Harbour Energy: Deadline 7 Submission.

Further to the submission by Harbour Energy and the Applicant of their respective preferred protective provisions at Deadline 6 (REP6-040 and REP6-049) the parties have continued discussions relating to both the protective provisions and the draft coexistence agreement. As explained at Deadline 6, the hope was that the parties could reach agreement to allow the ExA to dispense with the need to include a set of protective provisions in the recommended DCO.

The Protective Provisions sought by Harbour Energy remain as outlined and explained in our Deadline 6 submission (Rep 6-040).

G7.13
Ver. A

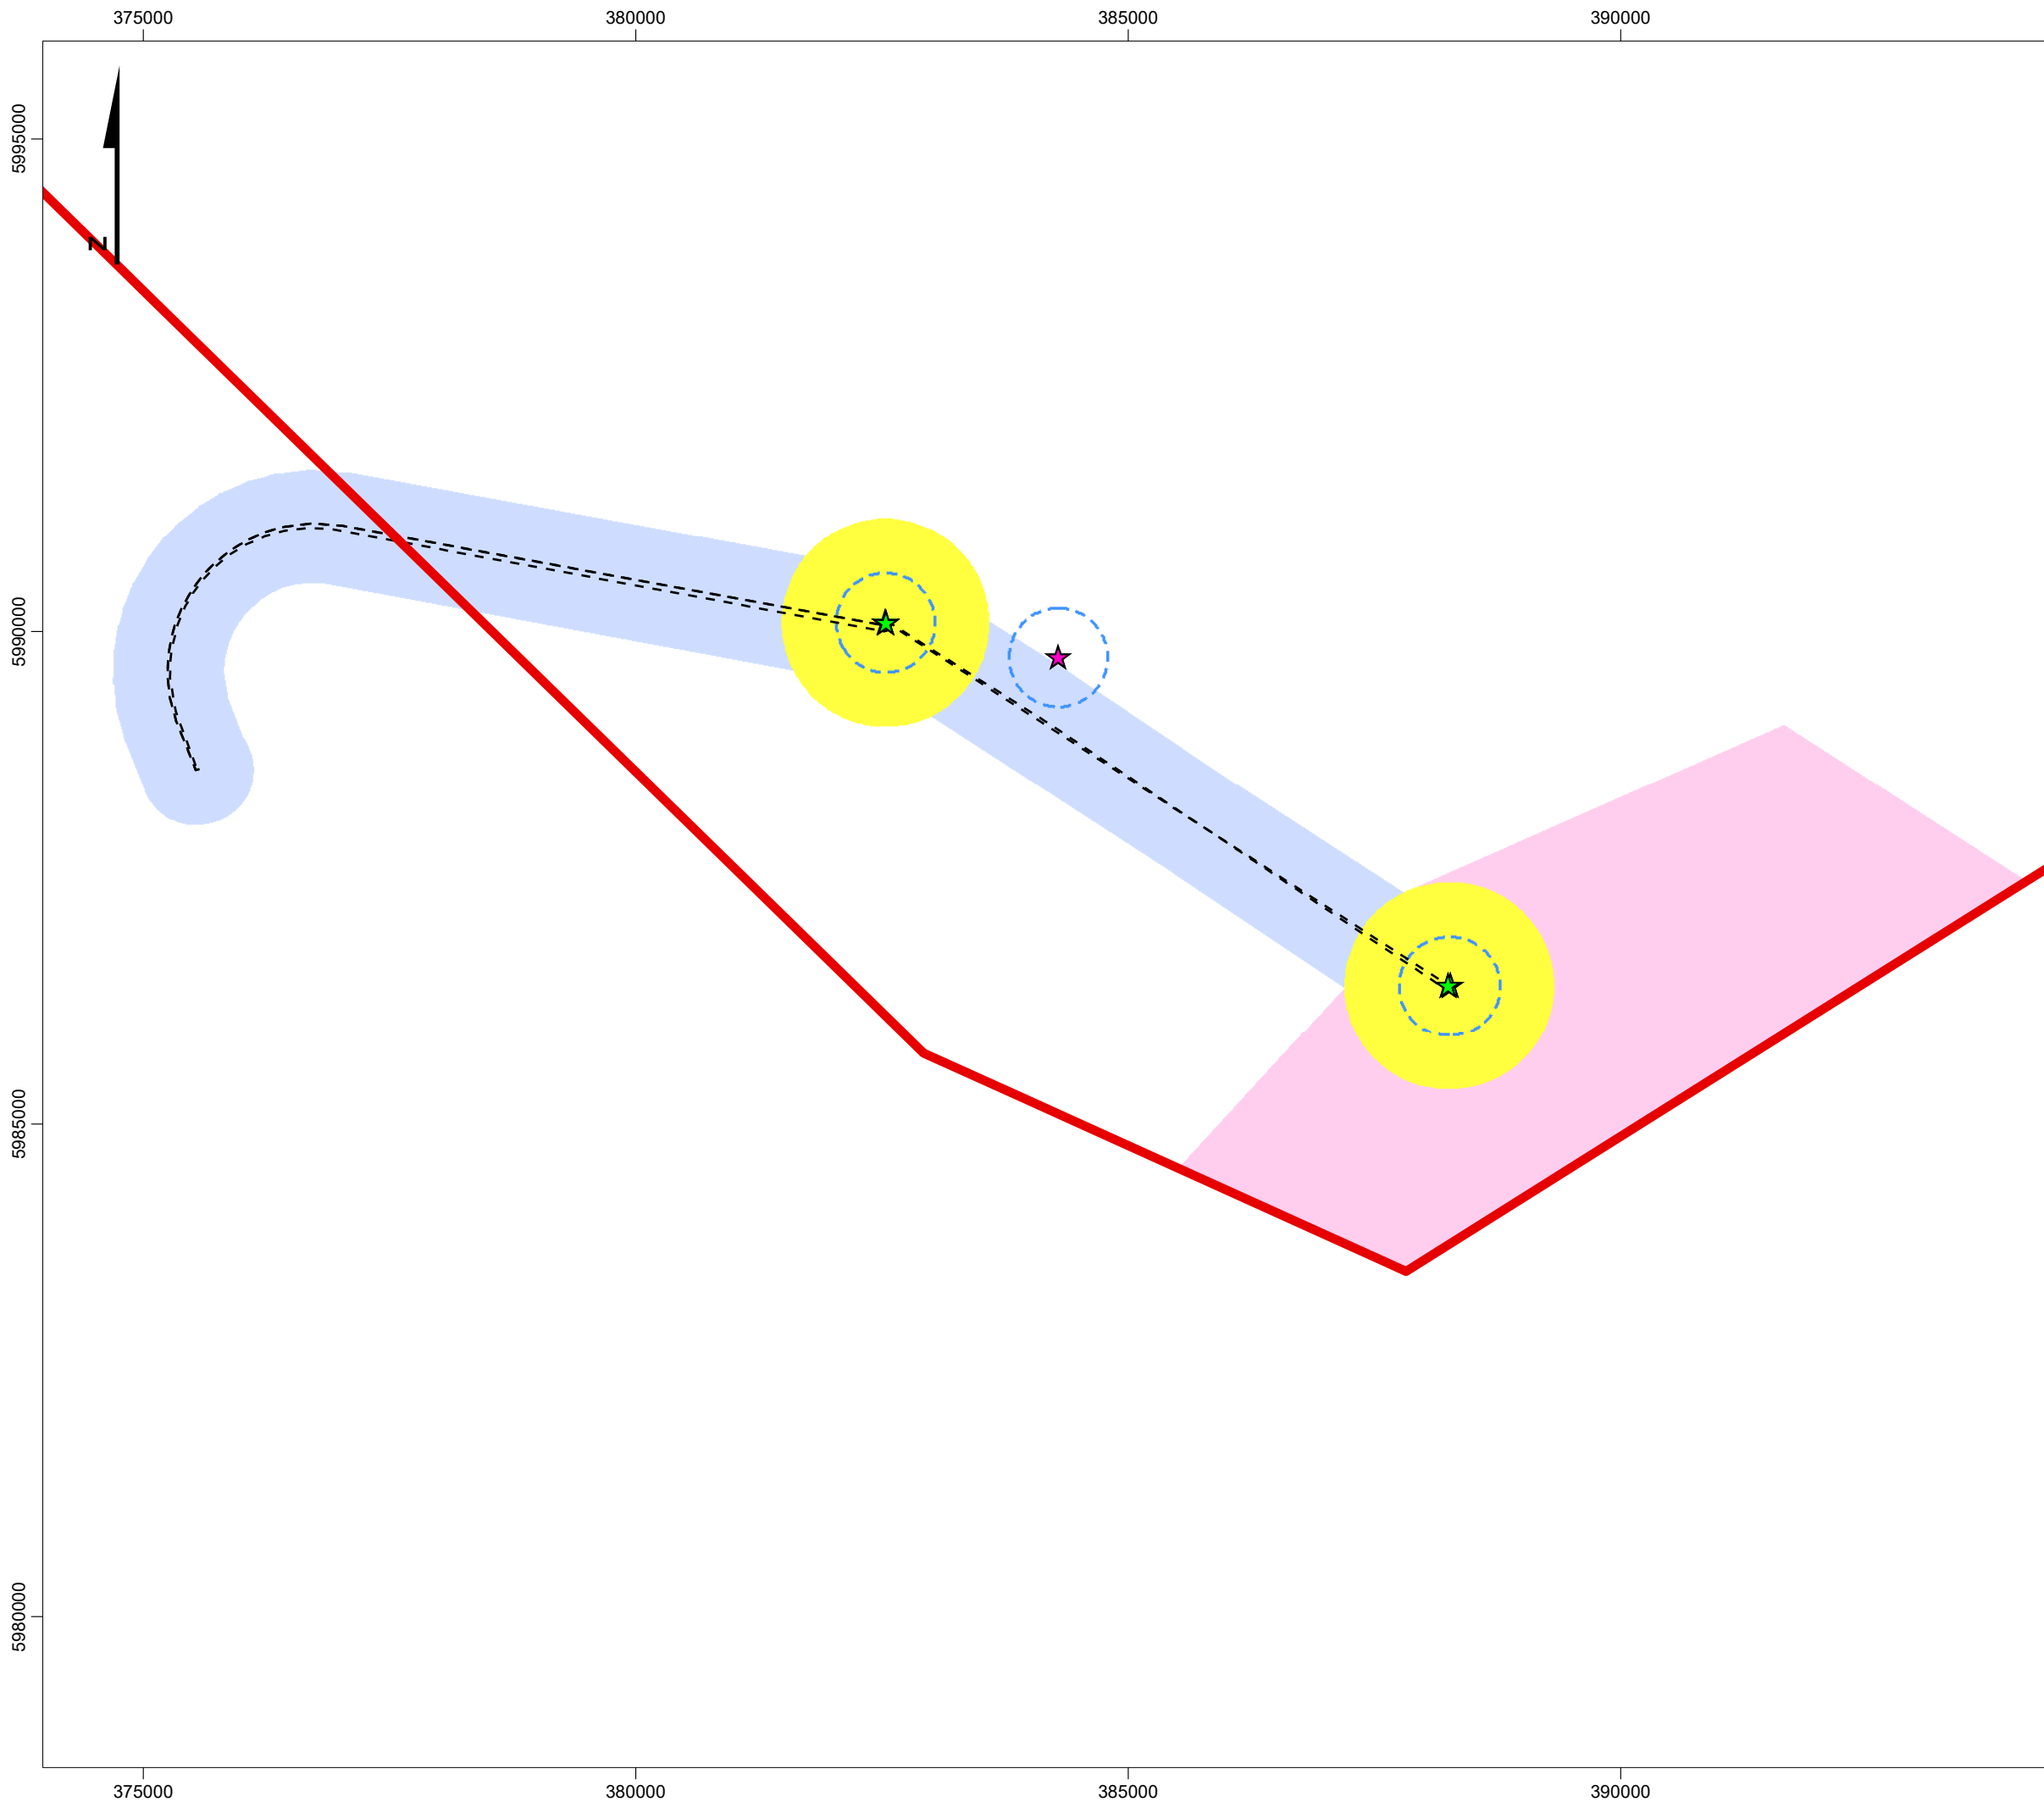
1. At para 3.1.1.1, the Applicant implies that the issue of helicopter access applies only to “the relatively short period required for plugging and abandonment of the producing wells only.” Whilst it is true that helicopter access will be required during the plugging and abandoning of the Johnston wells, helicopter access may also be required prior to cessation of production should there be a need for a rig to undertake well interventions in order to restore or improve the productivity of the wells. It should further be noted that such interventions could be required of the Johnston owners by the industry regulator under the terms of the Johnston production licence.

2. The Applicant stresses in para. 3.1.1.1 that the period of rig access would be “relatively short”. The use of a rig for a well intervention would under normal circumstances be for a period of around 1 month. Under normal circumstances the plugging and abandoning of the wells could be undertaken within a period of 6 to 9 months. It is acknowledged that these are short timescales in comparison to the expected life of the Hornsea Project Four wind farm, but never-the-less represent very significant capital expenditures. It should also be noted that these timings could be substantially increased by the presence of the windfarm.

3. At para 3.1.1.1, the Applicant “maintains that this [i.e. delays to flights due to the presence of wind turbines] would be a minimal impact” and at para 4.1.1.1, the Applicant asserts that their proposal would be “a minor inconvenience for helicopter access”. This language fails to recognise the true impact should turbines be sited in close proximity to the wellheads. Harbour Energy has been advised by helicopter operators that, for the payloads and helicopter types required to service rig operations (which differ from the smaller, more manoeuvrable aircraft used to maintain offshore wind installations), it would not be possible to take off from a rig with wind turbines located within 500m. Thus, far from the applicant’s statement at 3.1.1.1, that the impact would be limited “to a small proportion of flights that could be delayed due to the presence of the wind turbines during certain weather conditions”, the Applicant's proposed Protective Provisions would make helicopter

operations practically impossible and leave Harbour Energy unable to fulfil its legal obligation to decommission the field.

4. Should the Applicant propose revised Protective Provisions that would make it possible, under certain weather conditions, for flights to operate to and from a rig at both of the Johnston wellheads, due consideration would need to be given to the likelihood of not being able to reach the rig with essential personnel and/or equipment and the consequent delays (and associated costs) that Harbour Energy would experience to its rig operations. Both the Applicant and Harbour Energy have a common met-ocean dataset that allows this impact to be examined quantitatively.

5. Harbour Energy would like to draw the Examiners' attention to the fact that, whilst the Applicant refers throughout to the distances to wind turbines, airspace has to be free from obstructions and so needs to be described by the distance to the tips of the rotors, which Harbour Energy understands could have a radius of 152.5m.
